**Re: SSD-5339 - Proposed Minto Resource Recycling Facility
No. 7 MONTORE ROAD, MINTO**

I refer to the Department's correspondence regarding the proposal to operate a resource recovery facility which will have the capacity to process 450,000 tonnes per annum of concrete, brick, asphalt, sandstone and sand from the building and construction industry. The facility also proposes a range of crushing, screening, sand washing equipment used to process this material, including a pug mill.

DRAWING TITLE				
DRIVEWAY PLAN				
PROJECT NO.	PLANSSET NO.	RELEASE NO.	DRAWING NO.	REVISION
P1203464	PS02	R21	PS02-F101	F

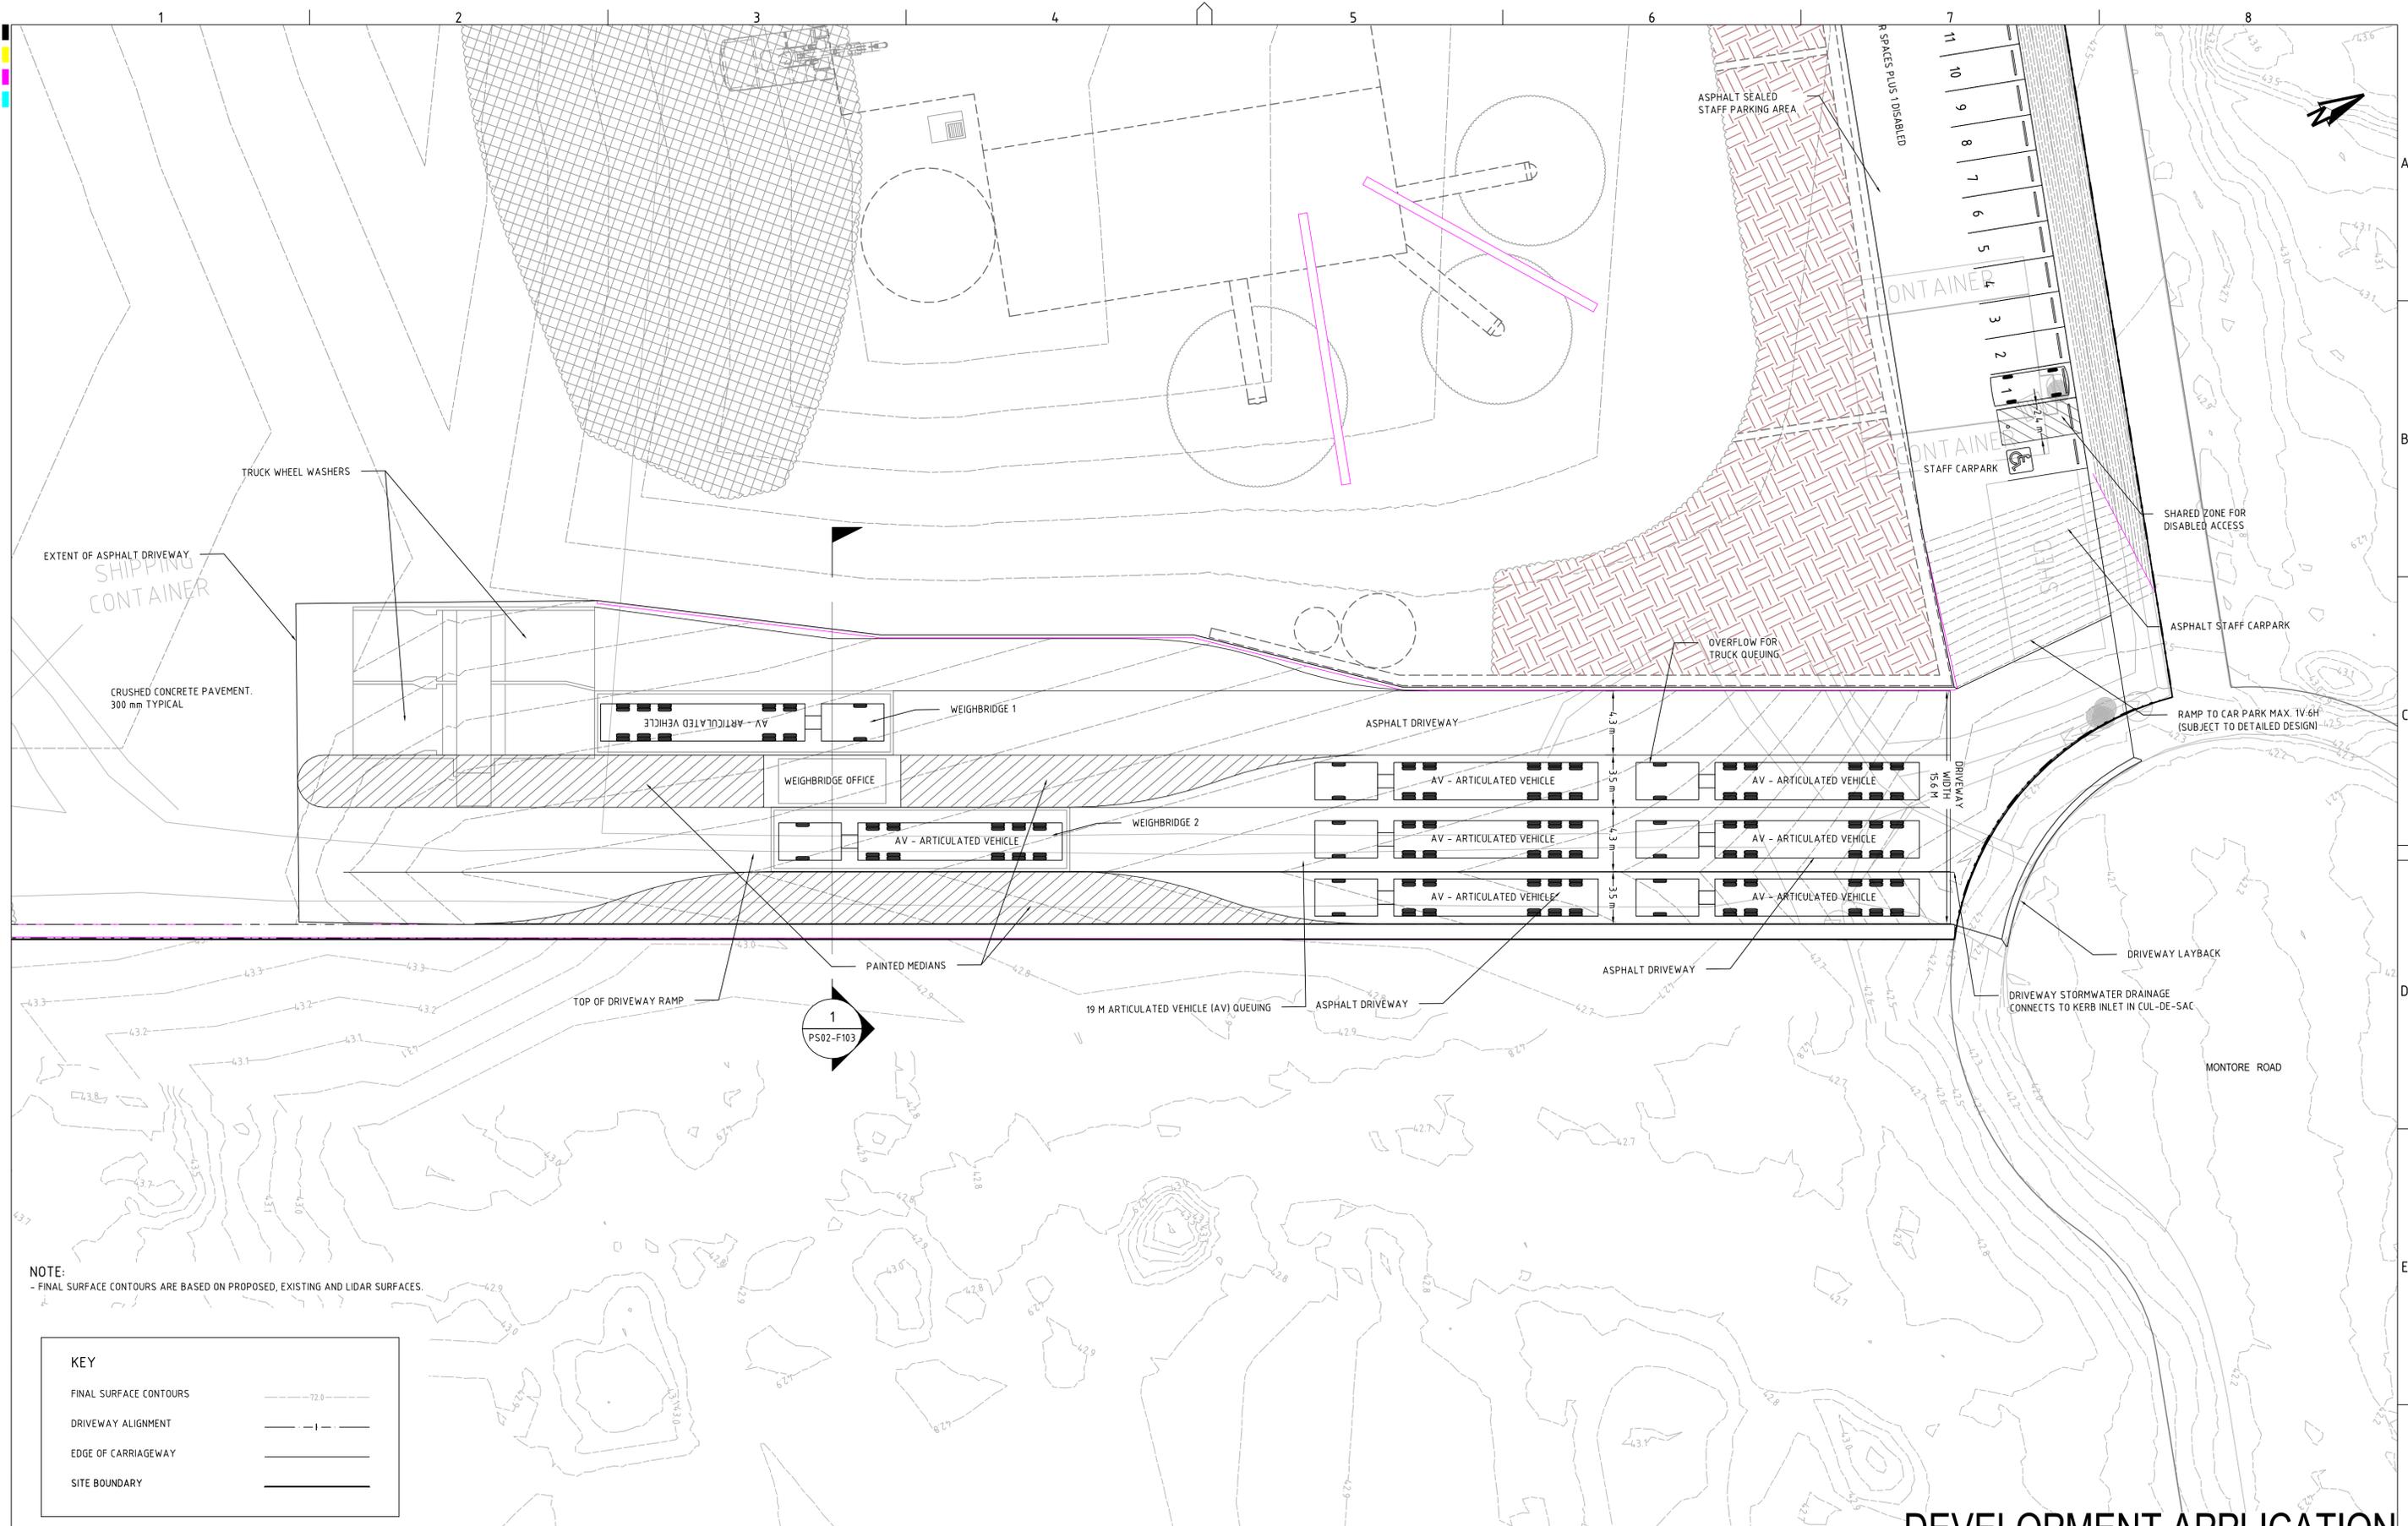
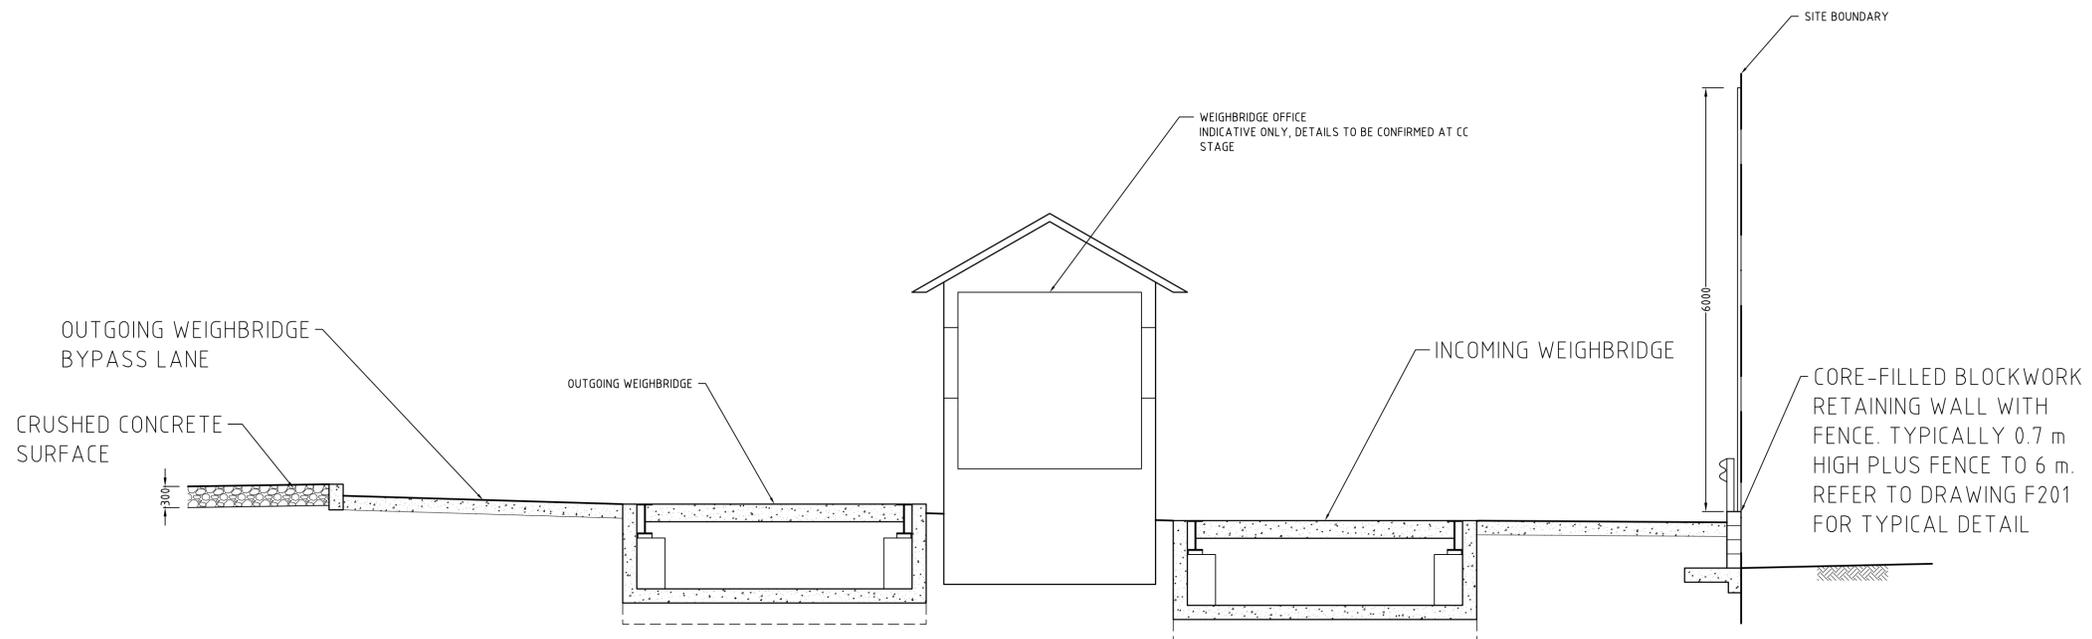
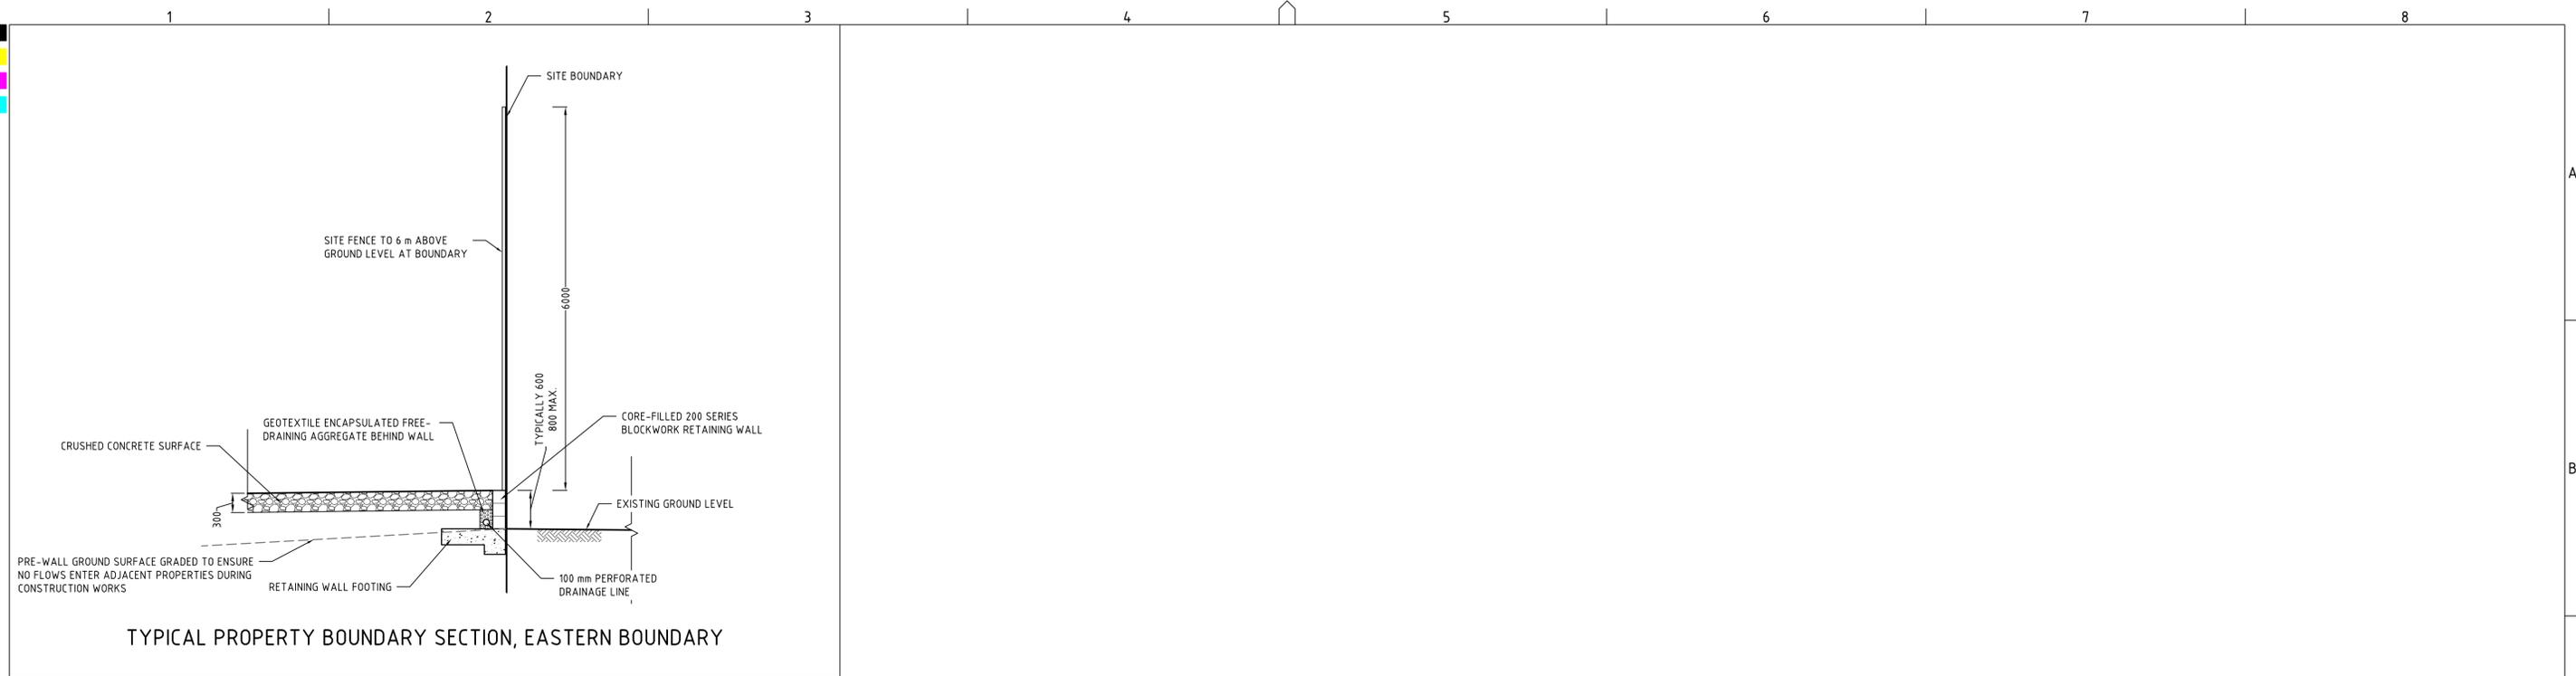
- Ensure that the vehicle crossing profile complies with Council's standard drawing SD-R09 Sheets 1 & 2 available on Council's website under Appendix K of the Council's Engineering Guide for Development

- Vehicle crossing shall be designed to provide safe clearance from streets' light pole as per Australian and Endeavour Energy standards
- Council has completed traffic surveys in 2017 and traffic modelling on some of the intersections included in this proposal. Council's modelling identified levels of service significantly lower than those identified in this proposal for the existing conditions. The modelling needs to be addressed by the applicant to better represent the site conditions
